Appeal Decisions

2 Linksway, Northwood HA6 2XB

Appeal A: APP/R5510/C/17/3172497

Appeal B: APP/R5510/D/17/3176155

AS BUILT FRONT ELEVATION (A)

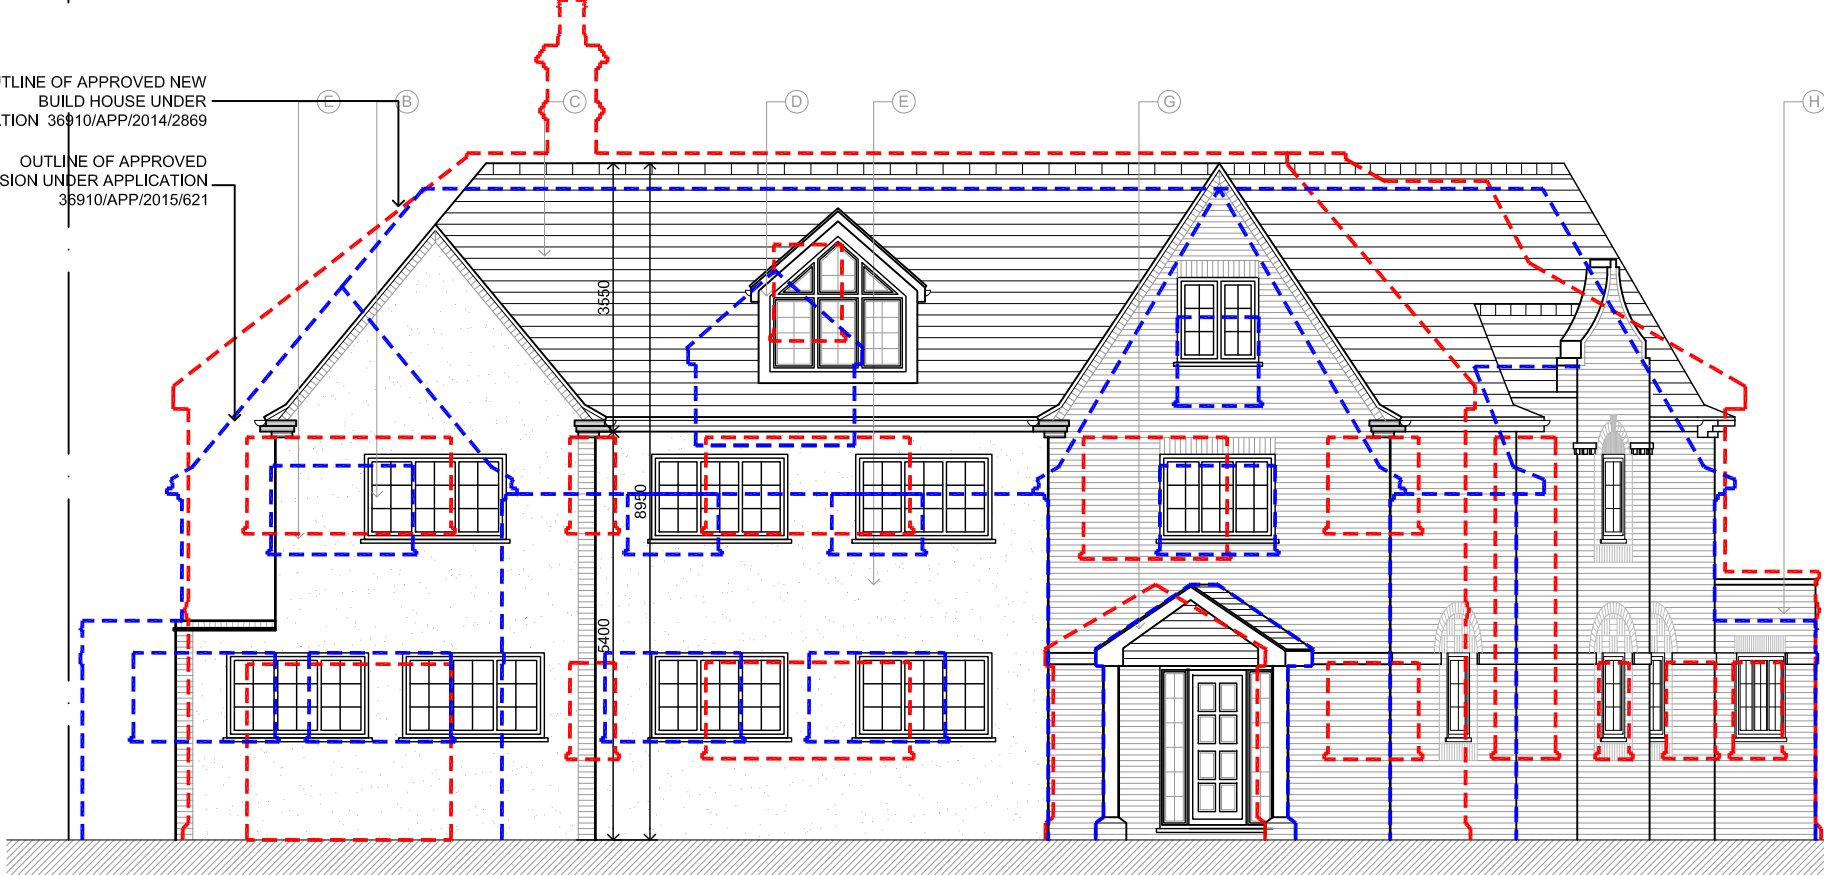
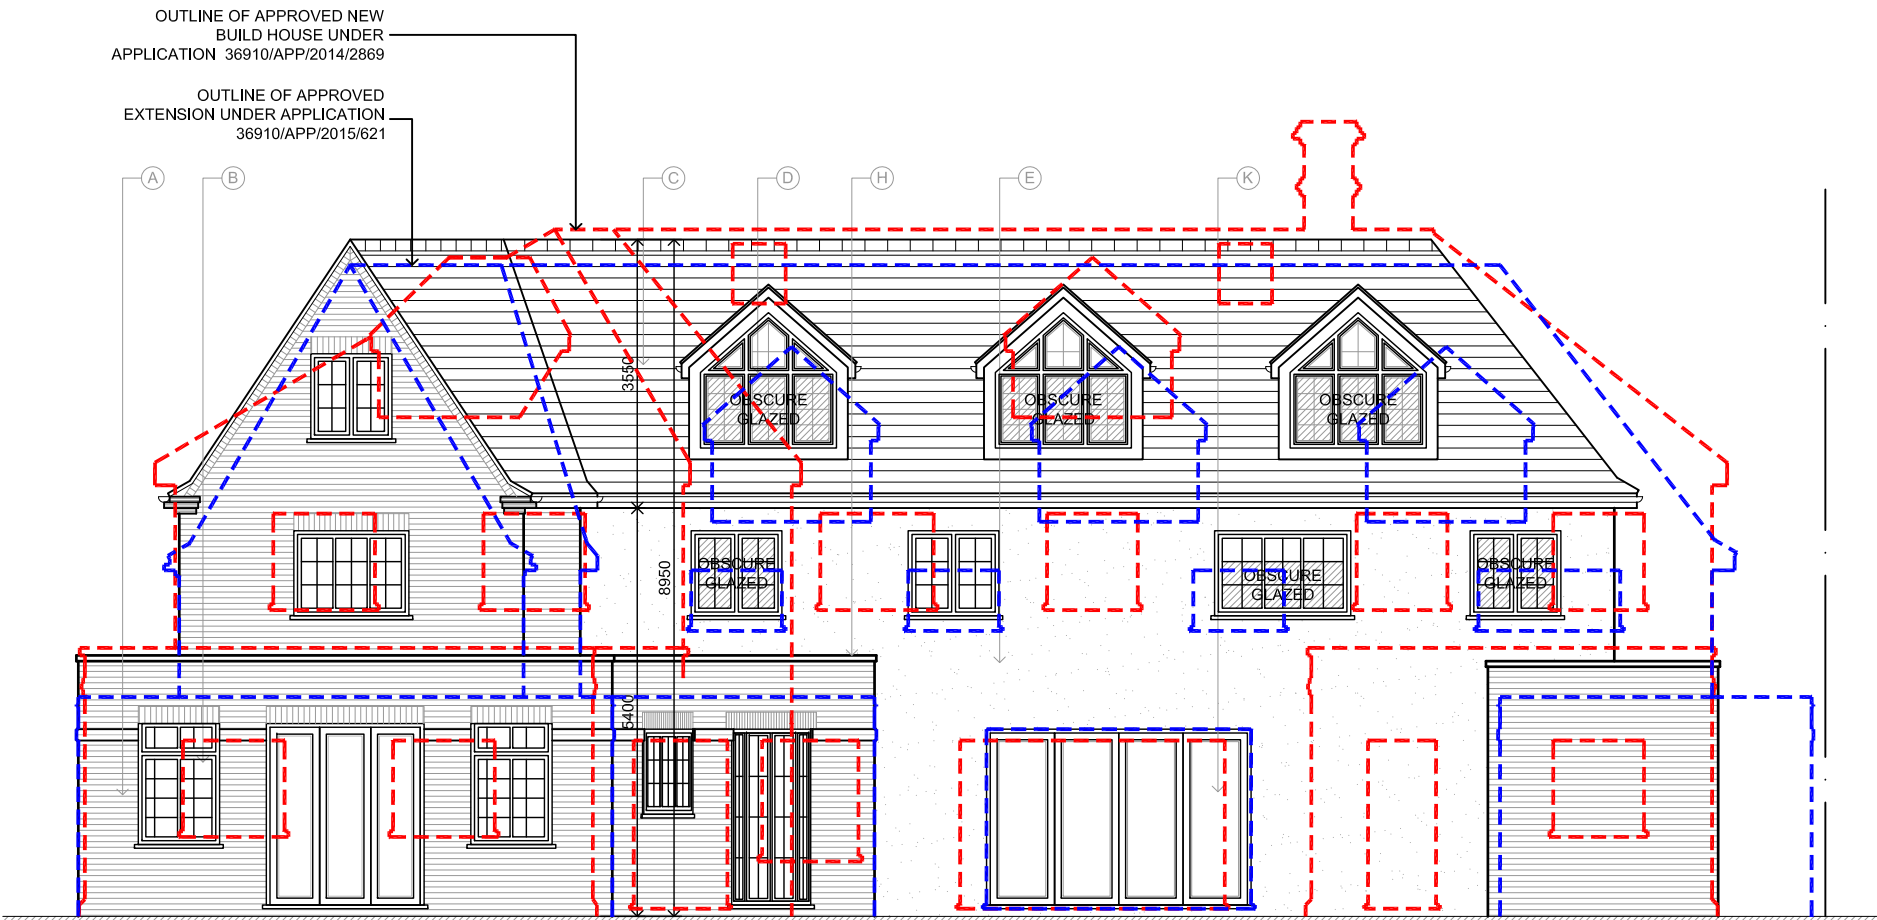
8. The parties agree that the main differences between the approved and built development are (i) the extended property has been stepped in from the southern side boundary (ii) the eaves height of the main roof has been raised by 0.825m to 5.4m (iii) the ridge height has been raised by 0.335m to 8.95m (iv) the rear facing dormer windows now all serve a bedroom (v) first floor windows have been altered and enlarged (vi) the height of the flat roofed single storey element has been raised and incorporates a parapet wall.
9. Internal changes have been made to the layout from that approved with consequential alterations to the exterior. There is an enlarged fifth bedroom which is served by all of the rear facing dormer windows instead of one window with the others serving an en-suite bathroom and storage space. Temporary obscured glazing has been undertaken to some windows.

14. Now that the eaves are raised, the proportions of the property have altered in consequence. The height of the vertical walls has increased leading to larger areas of blank wall. The roof is also shallower than the scheme approved because the ridge height has not increased to the same degree as the eaves. The single storey element to the side and rear is also higher and incorporates a parapet wall. These may be notable differences between the two sets of plans, but when viewing the property from the street or rear garden, they are not particularly significant in terms of visual impact. The roof does not appear unusually shallow in the context of its surroundings or cause the roof dormers to seem overly pronounced. Nor does the side extension appear disproportionate to the rest of the dwelling.

22. The internal reconfiguration has resulted in a second roof dormer serving a bedroom instead of a bathroom. There is also a larger bedroom window on the first floor where there would have been an en-suite bathroom. These first and second floor level windows face towards the boundary with neighbouring No 3 Copse Wood Way. Its flank wall is estimated to be around 10m away.

23. Plastic film has been attached to some upper rearward facing windows and retaining straps fitted to restrict their opening. Clearly, these measures could be removed easily at any time. If that were to happen then there would be direct views of the rear garden of No 3 at quite close range even though the first floor bedroom (identified in the plans as 'bedroom 3') is further away from the shared boundary than previously approved.

24. Indeed, whilst there was opaque film stuck to the first floor en-suite bathroom for bedroom 3, the bedroom window itself was clear glazed. The patio closest to the house at No 3 was visible as were other parts of the garden. This is overly intrusive given the size, position and distance of the window to the neighbouring rear garden. It gives rise to an unacceptable interference with the privacy of neighbours using their garden. That is so irrespective of whether the approved scheme allowed a smaller (bathroom) window in a similar position without any restriction on the type of glazing.

31. It seems to me that a condition for obscured glazing and limited window openings would address the harm arising to neighbouring privacy if also imposed in relation to the roof dormers for the bedroom identified as 'bedroom 5' on the plans. I note that only one of these windows served a bathroom under the approved scheme and that no condition was imposed to ensure it was

obscured glazed. Nevertheless, both windows are at a height, orientation and proximity to the shared boundary so as to cause an unreasonable interference with privacy if not obscured glazed and with restricted openings.

- (i) within 3 months of the date of this decision, a scheme for the replacement of the upper floor windows identified as bedrooms 3 and 5 (including the en-suite for bedroom 3) on drawing No A203 Revision C with obscure-glazed windows to be fixed shut to an internal height of 1.7m, shall have been submitted for the written approval of the local planning authority and the scheme shall include a timetable for its implementation.

- (3) Notwithstanding the provisions of the Town and Country Planning (General Permitted Development)(England) Order 2015, (or any Order revoking, re-enacting or modifying that Order), no additional windows, doors or openings shall be formed in the walls or roof slopes of the development hereby approved on any elevation facing No 3 Copse Wood Way.
